**Application by Four Ashes Limited for the West Midlands
Interchange Strategic Rail Freight Interchange.**

**Written Representations following the Preliminary Meeting by
Deadline 2**

**Subject of this Submission:
Highways and Movement Issues**

**Campaign to Protect Rural England (Staffordshire Branch)
Inspectorate reference for this representee: 20015574**

TITLE  
 2021 SCHEME - BASE, AM PEAK HOUR (0800-0900), TRAFFIC FLOWS  
 Version 3, 09/10/2017

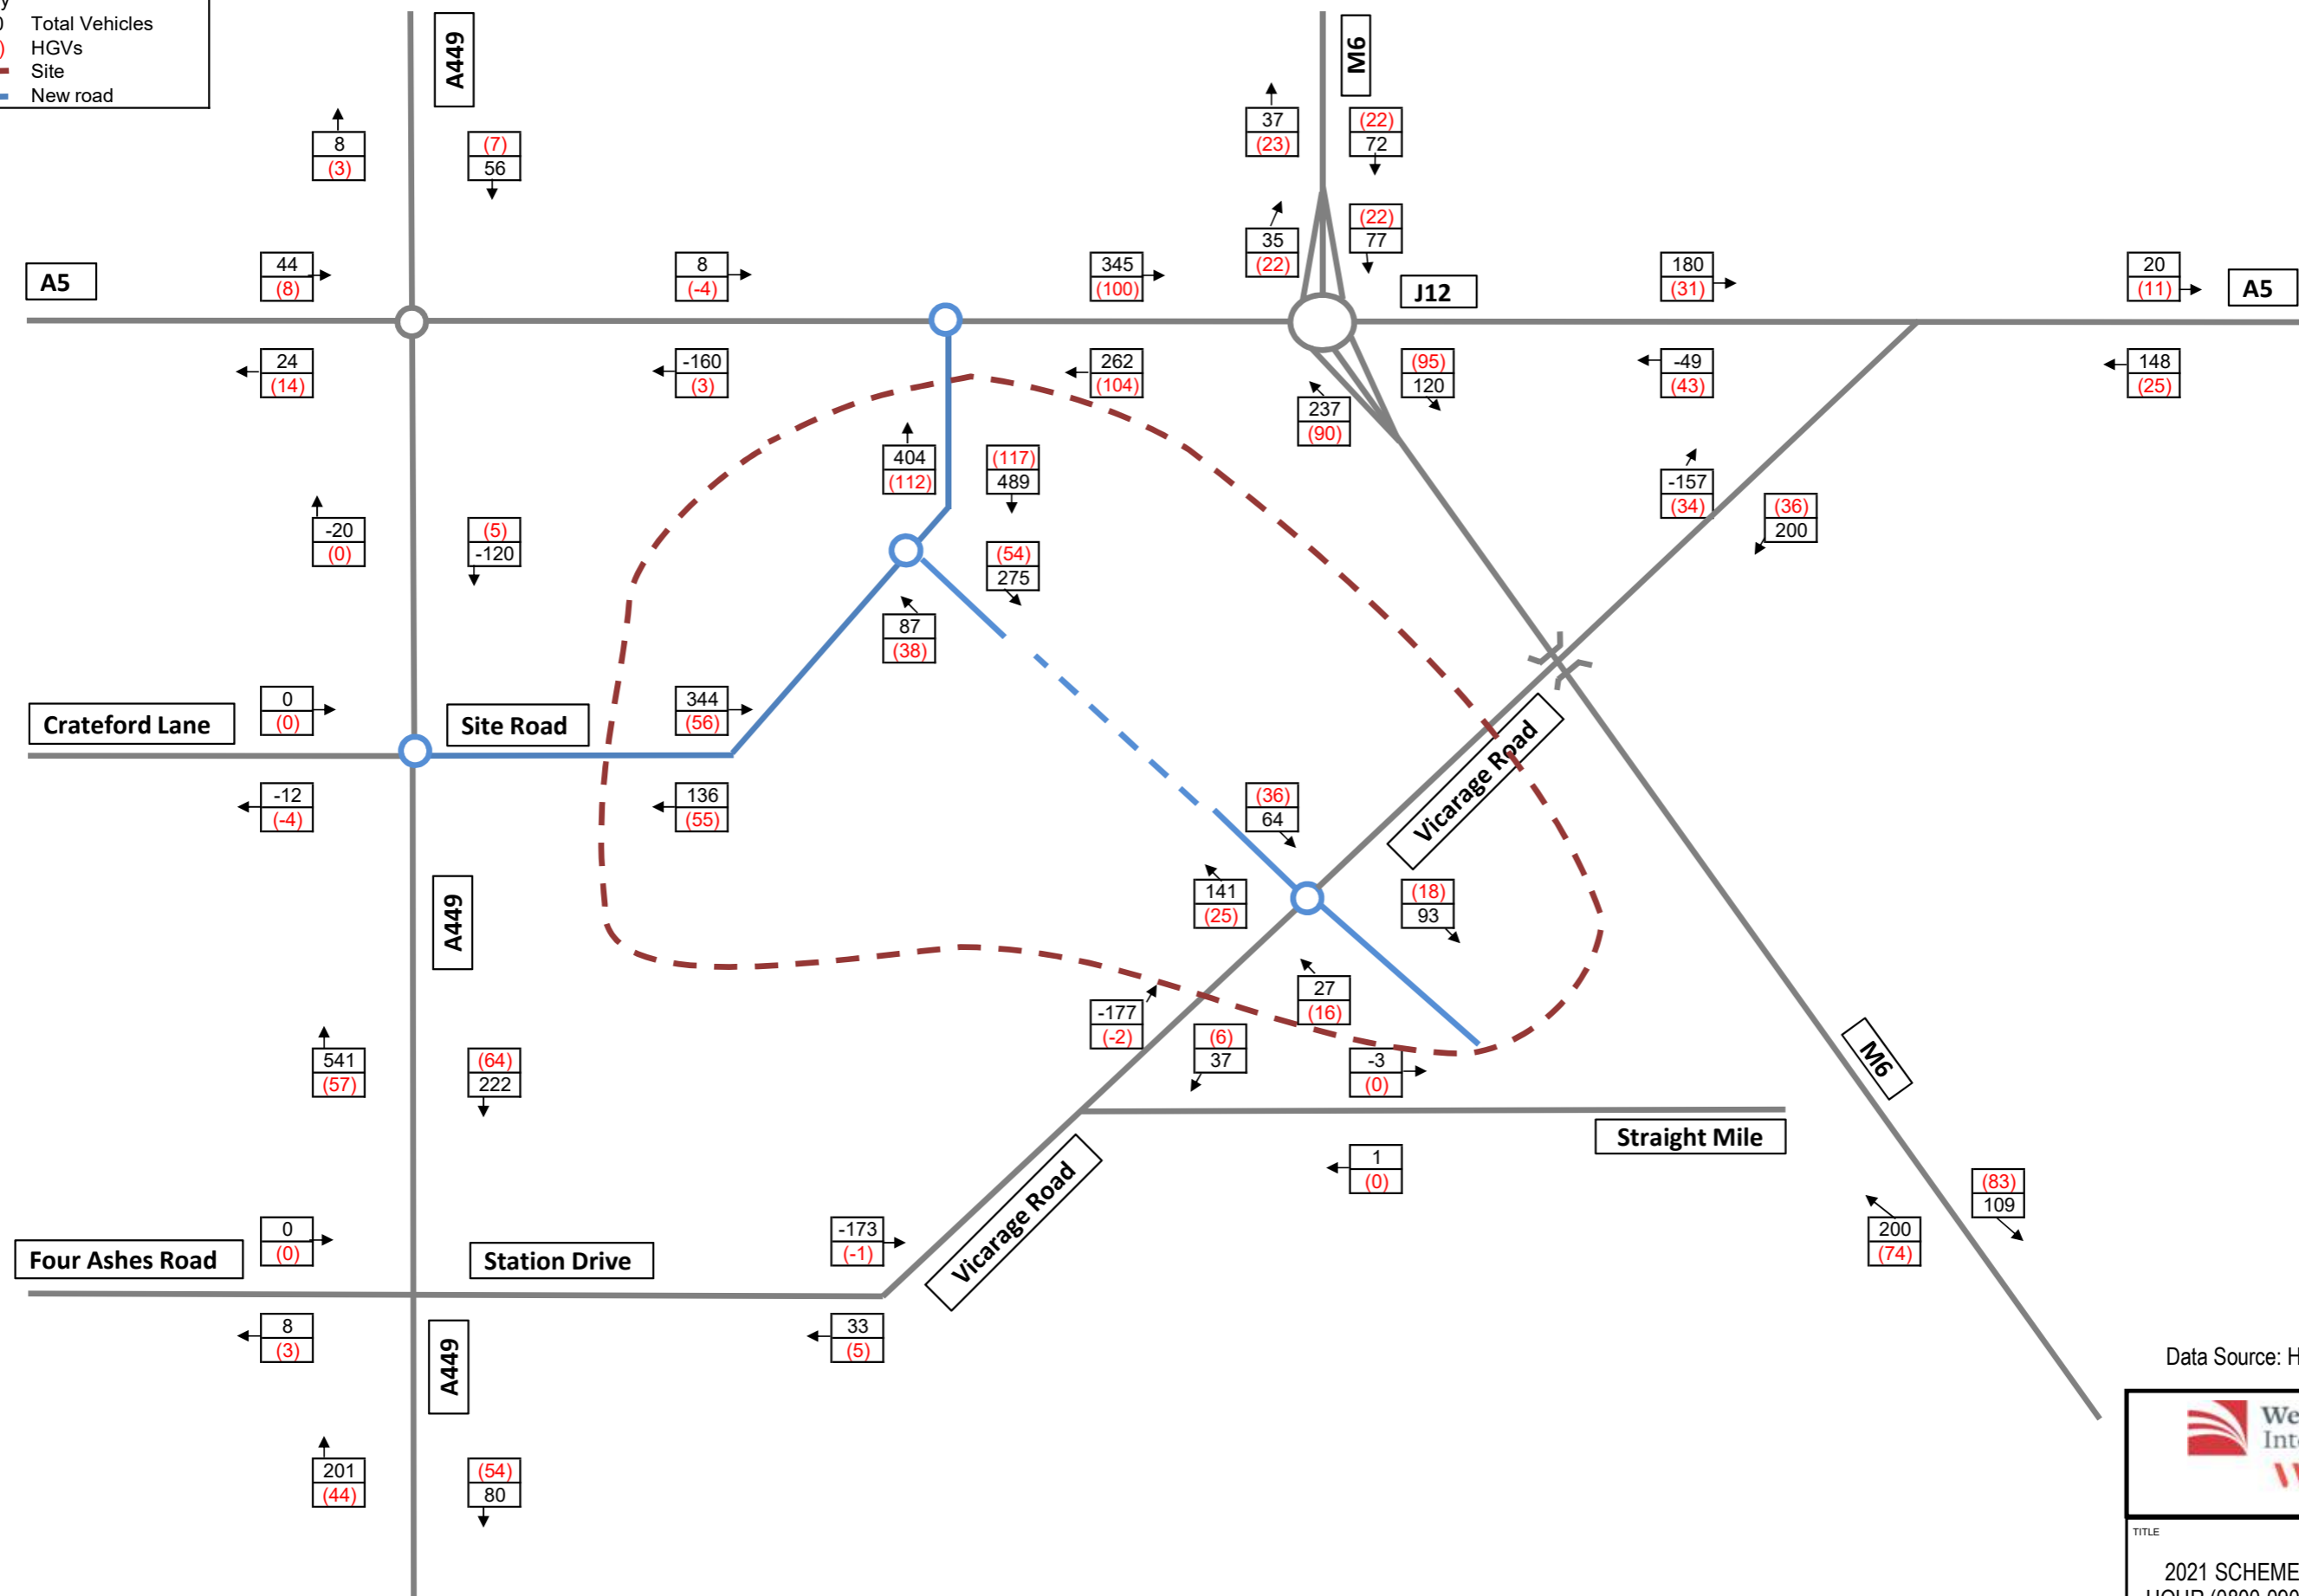
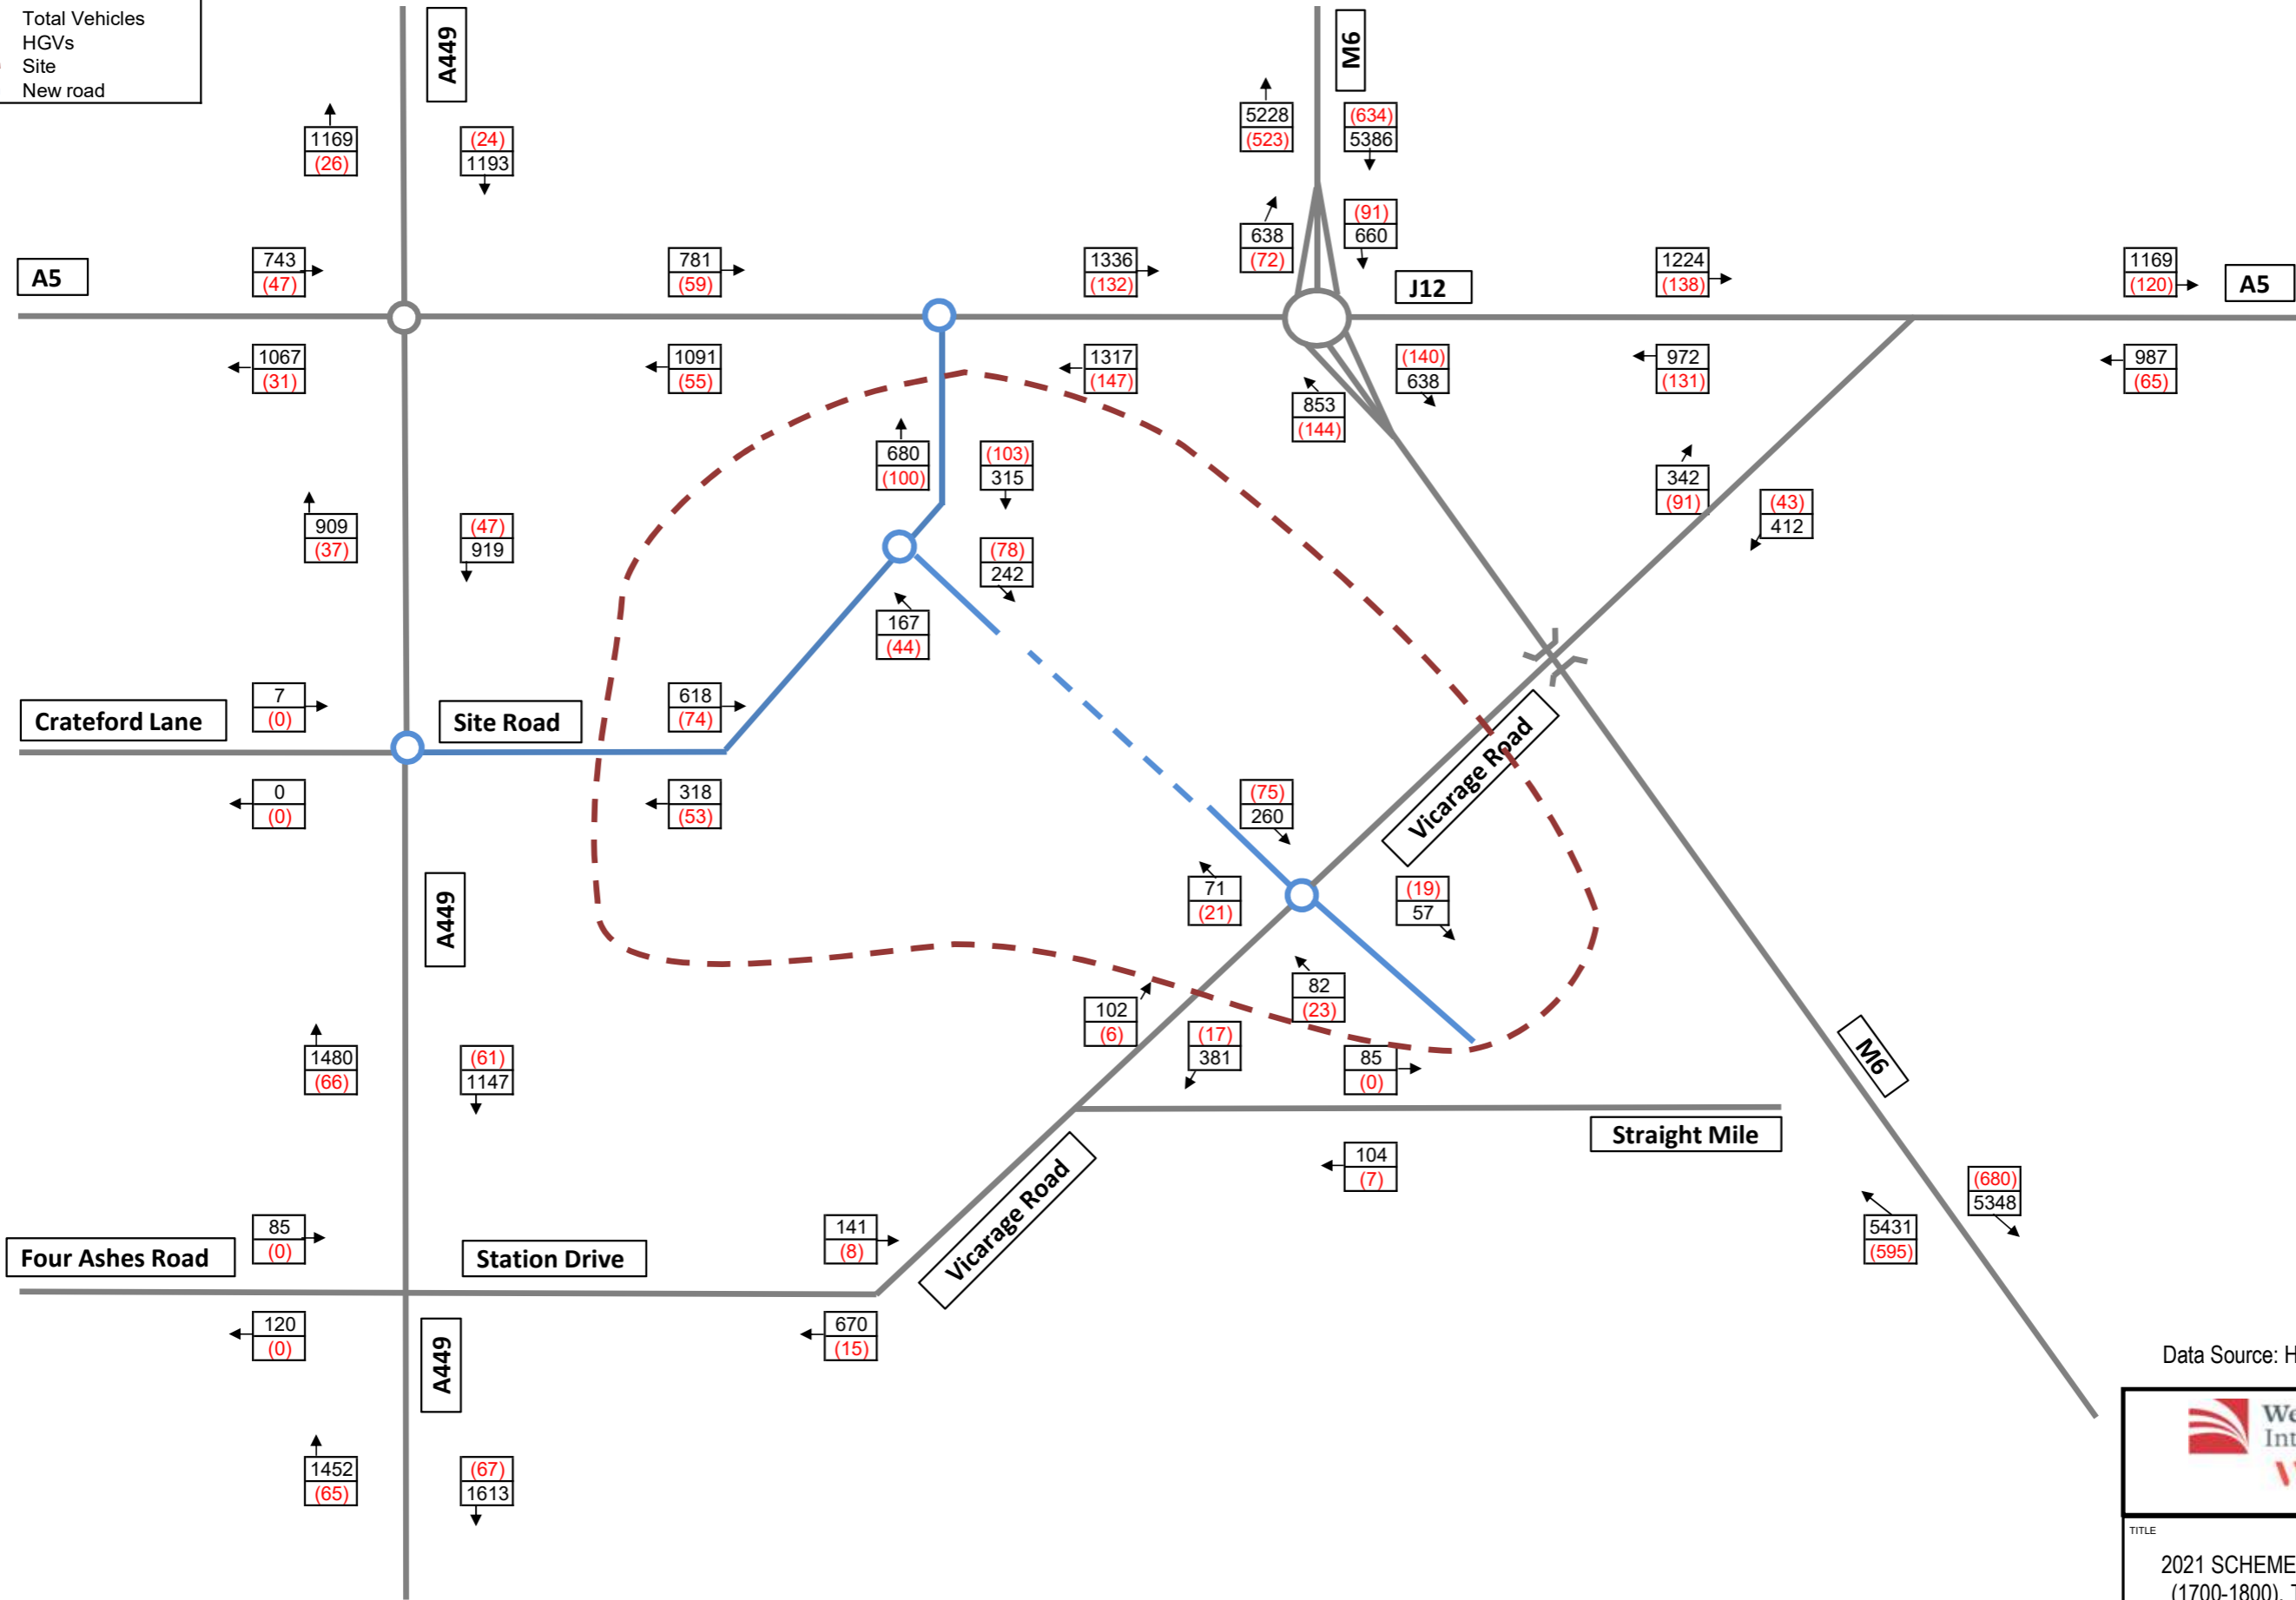
We have seen the Applicant's document¹ included in the application

We have searched the Inspectorate's database for representations from the Staffordshire County Council as Local Highway Authority. We found initial representations and the response to ExA's questions for response by the first deadline but nothing relevant to the issue which we, and others, have raised. We have not found a Memorandum of Understanding, or anything similar, from Staffordshire County Council, as Local Highway Authority to say that that it is satisfied that the scheme will not adversely affect residents and other highway users on the A449 through Penkridge, the A5 to the West of Gailey, the A5 to the east of J12 (particularly in the Bridgetown area of Cannock) - each of which will carry additional traffic.

As the ExA has already heard, there are local concerns as to the increased traffic which will travel north on the A449 via Penkridge. We acknowledge that the Applicants have put forward a scheme to monitor HGVs to and from the site using the A449 to/from the north but, as we said in our representation by the ExA's first deadline, we question the feasibility and practicality of this and would comment that it would only cover HGVs and would not include other vehicles nor would it include construction HGVs or sites within the SRFI without ANPR cameras fitted and monitored.

All traffic leaving the site and travelling west on the A5, (both of which must also use Gailey roundabout) would not be monitored. We would suggest that the Inspector might visit the Gailey roundabout in the early morning to see the existing traffic flows and balance of vehicle types. Travelling along the A5 to the west of the roundabout would also indicate why residents have concerns about the additional traffic likely to use the route.

We have not seen any comment from the Highway Authority on the impact of additional traffic to and from the site using the A5 east from M6 Junction 12 where there is already significant congestion to the south-west of Cannock.
